**City of Portland, Maine - Building or Use Permit Application**  
 389 Congress Street, 04101 Tel: (207) 874-8703, Fax: (207) 874-8716

<b>Permit No:</b> 05-1771	<b>Issue Date:</b>	<b>CBL:</b> 430 A010001
------------------------------	--------------------	----------------------------

<b>Past Use:</b> Residential 2 unit	<b>Proposed Use:</b> Two unit, demo 2 existing bldgs & rebuild both slightly smaller, w/12'x18' attached addition	<b>Permit Fee:</b> \$30.00	<b>Cost of Work:</b> \$1,000.00	<b>CEO District:</b> 4
<b>Proposed Project Description:</b> Two unit, demo 2 existing bldgs & rebuild both slightly smaller, w/12'x18' attached addition		<b>FIRE DEPT:</b> <input type="checkbox"/> Approved <input type="checkbox"/> Denied	<b>INSPECTION:</b> Use Group: Type	
		Signature:	Signature:	
<b>PEDESTRIAN ACTIVITIES DISTRICT (P.A.D.)</b>				
Action: <input type="checkbox"/> Approved <input type="checkbox"/> Approved w/Condition <input type="checkbox"/> Denied				
		Signature:	Date:

**Dept:** Zoning      **Status:** Approved with Conditions      **Reviewer:** Marge Schmuckal      **Approval Date:** 12/15/2005

SITE PLAN

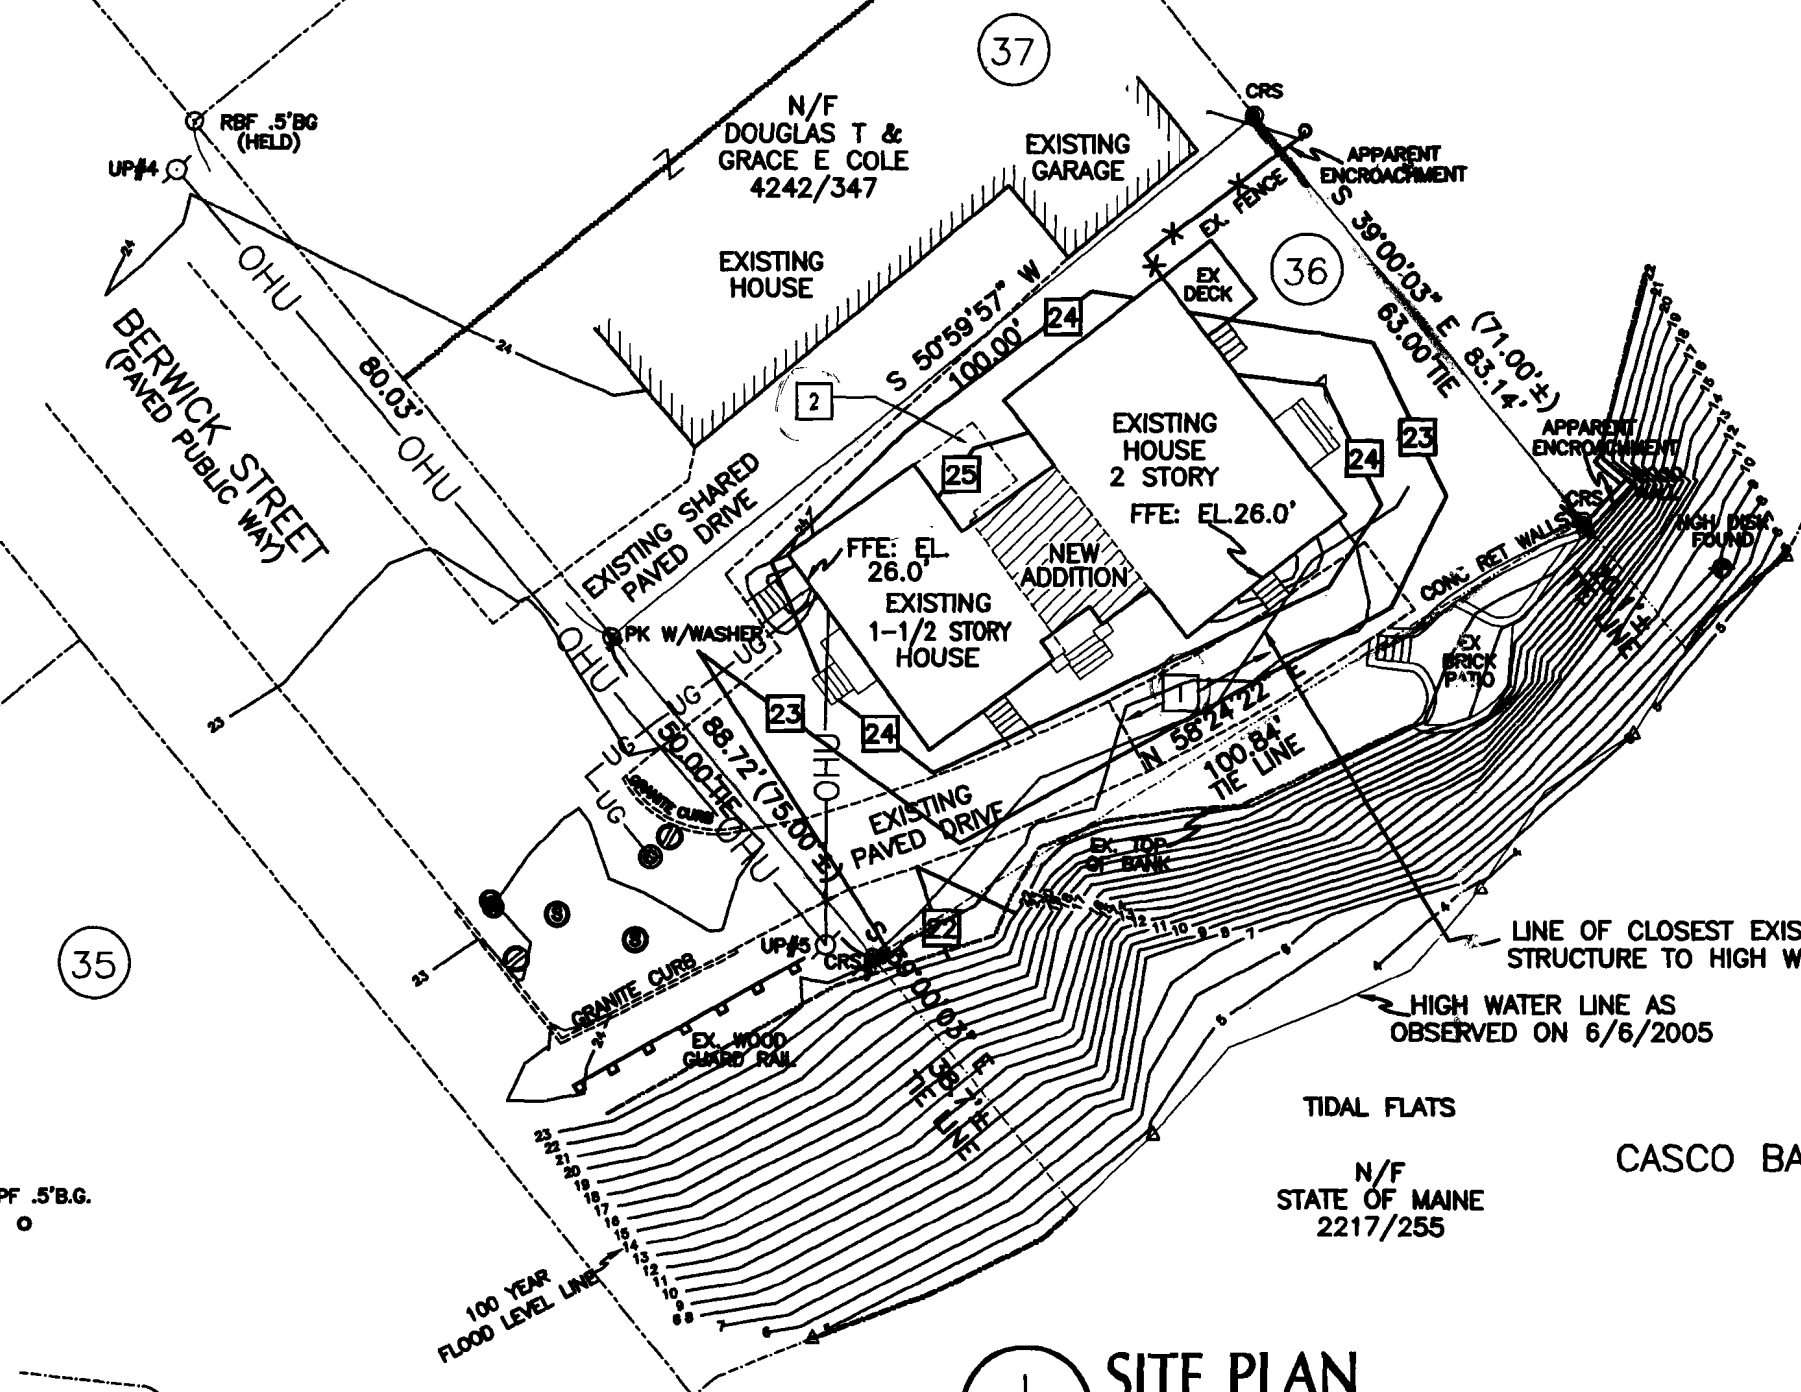
- 1) This property shall remain a two (2) family dwelling. Any change of use shall require a separate permit application for review and approval.
- 2) My conversation on 11/5/05 with Scott Taber confirmed that the driveway will not be eliminated or reduced in size. This full existing driveway is required to meet off street parking requirements.

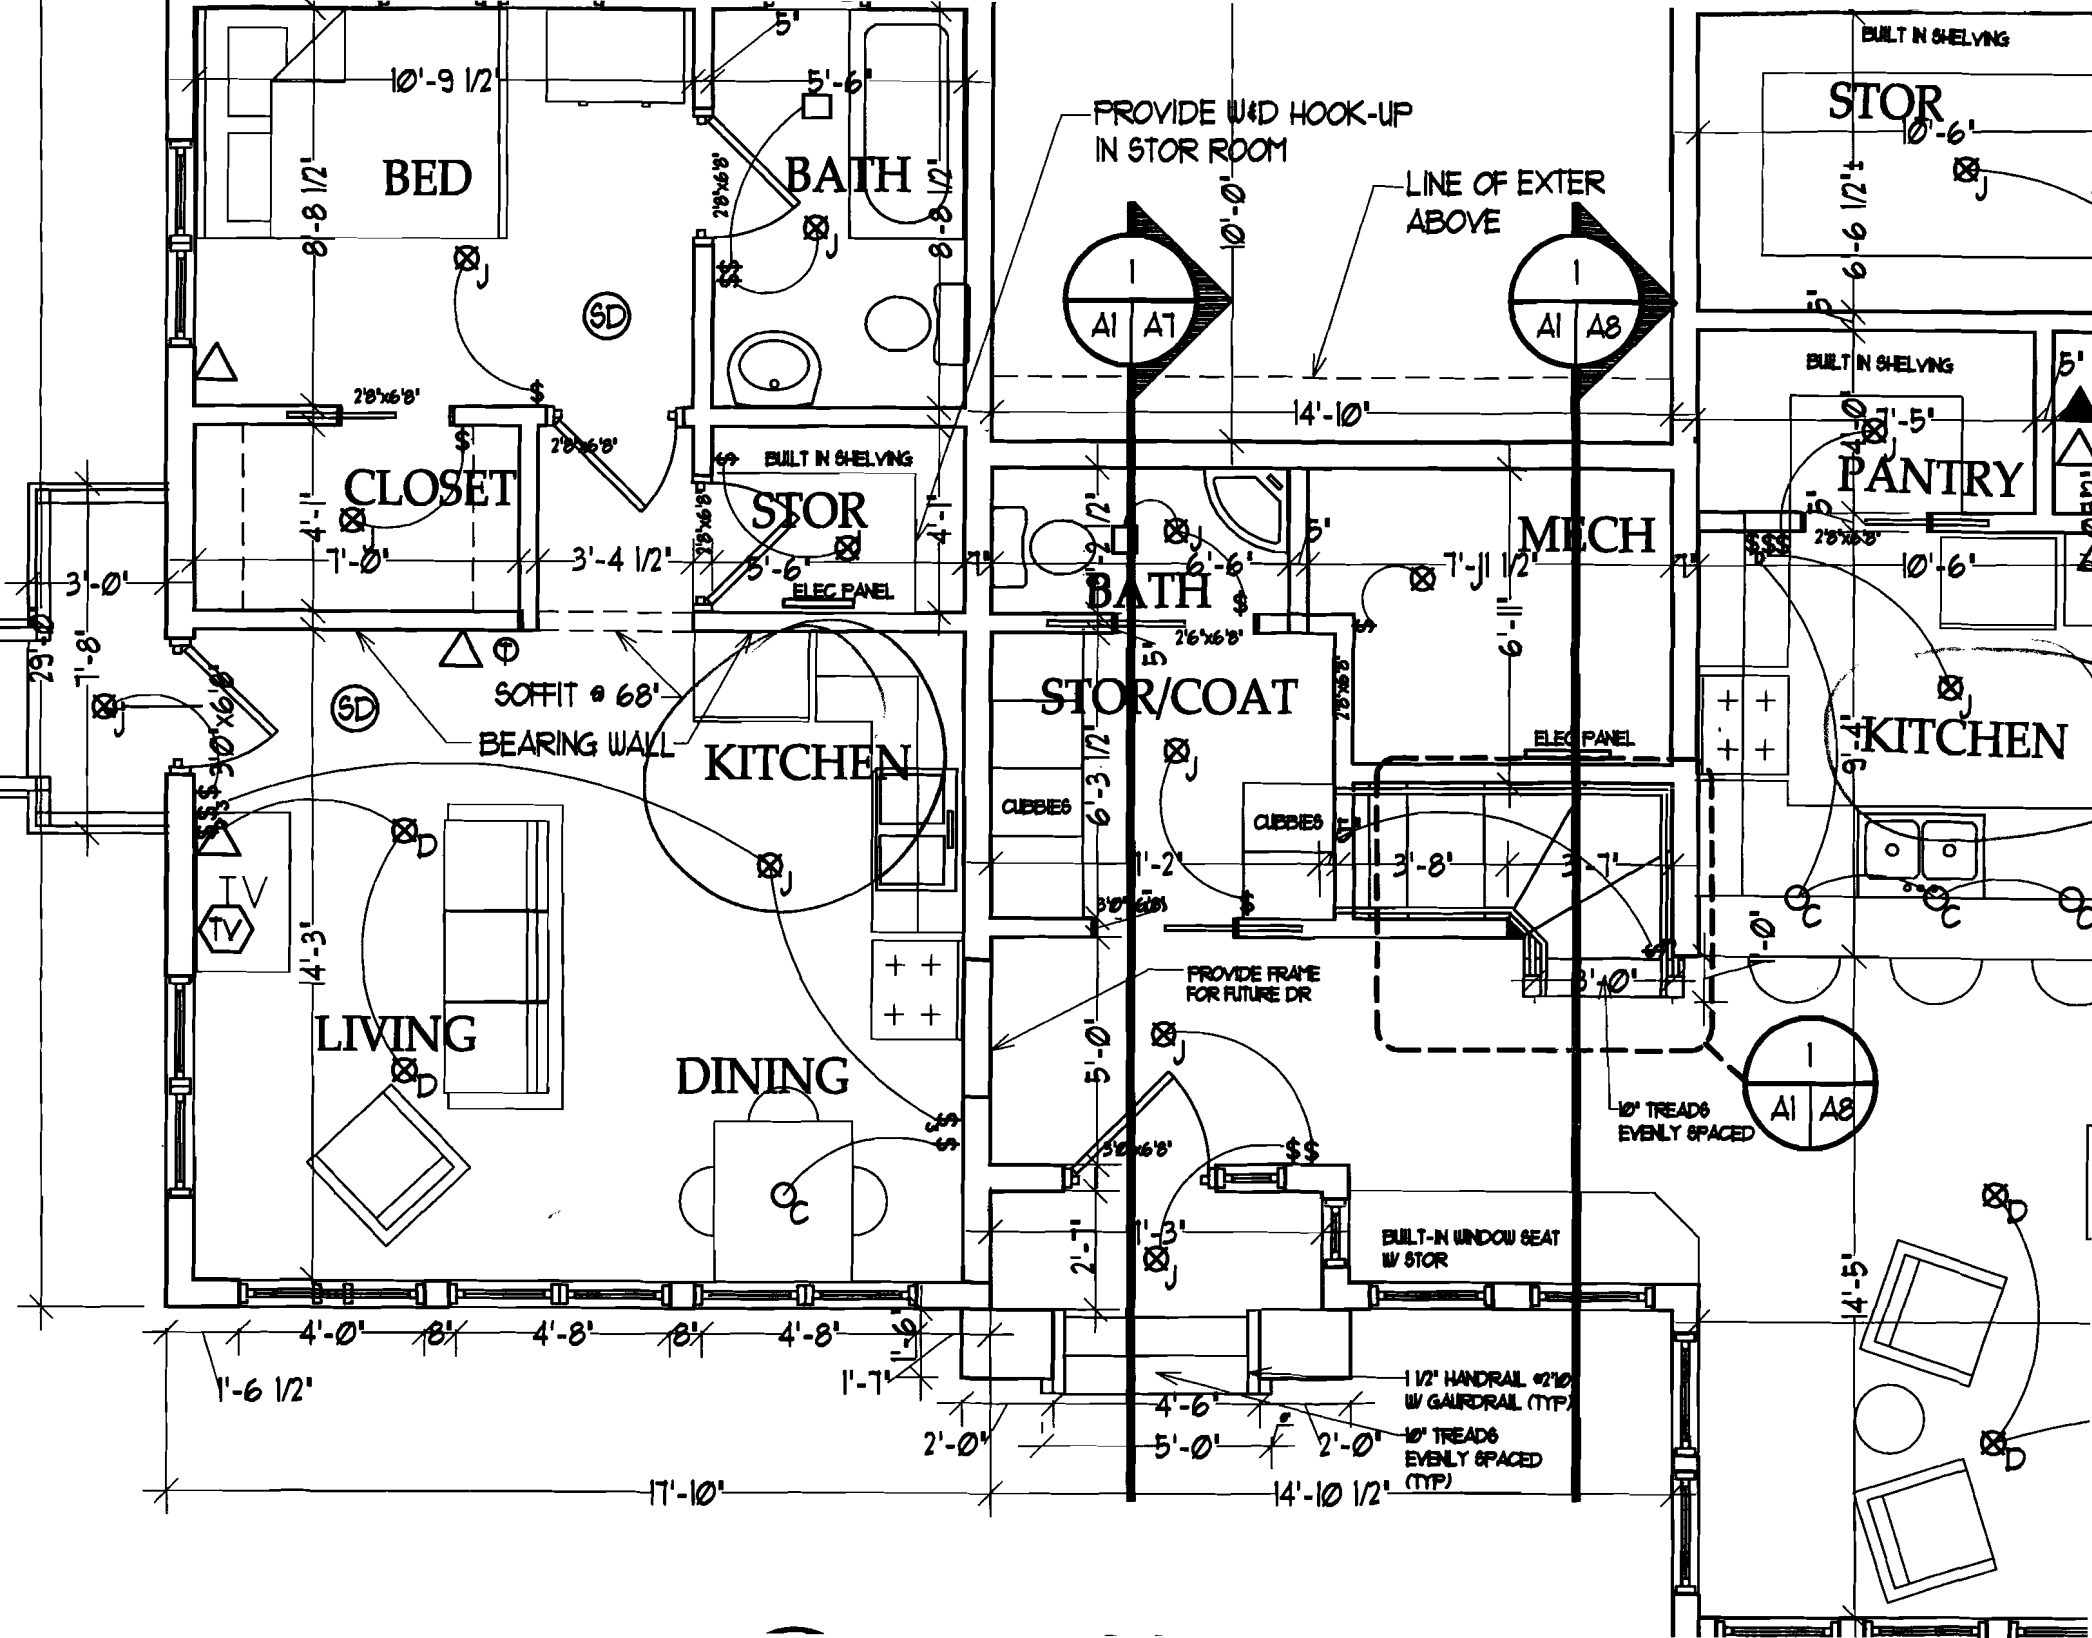
- 4) This is NOT an approval for an additional dwelling unit. You SHALL NOT add any additional kitchen equipment including, but not limited to items such as stoves, microwaves, refrigerators, or kitchen sinks, etc. Without special approvals.
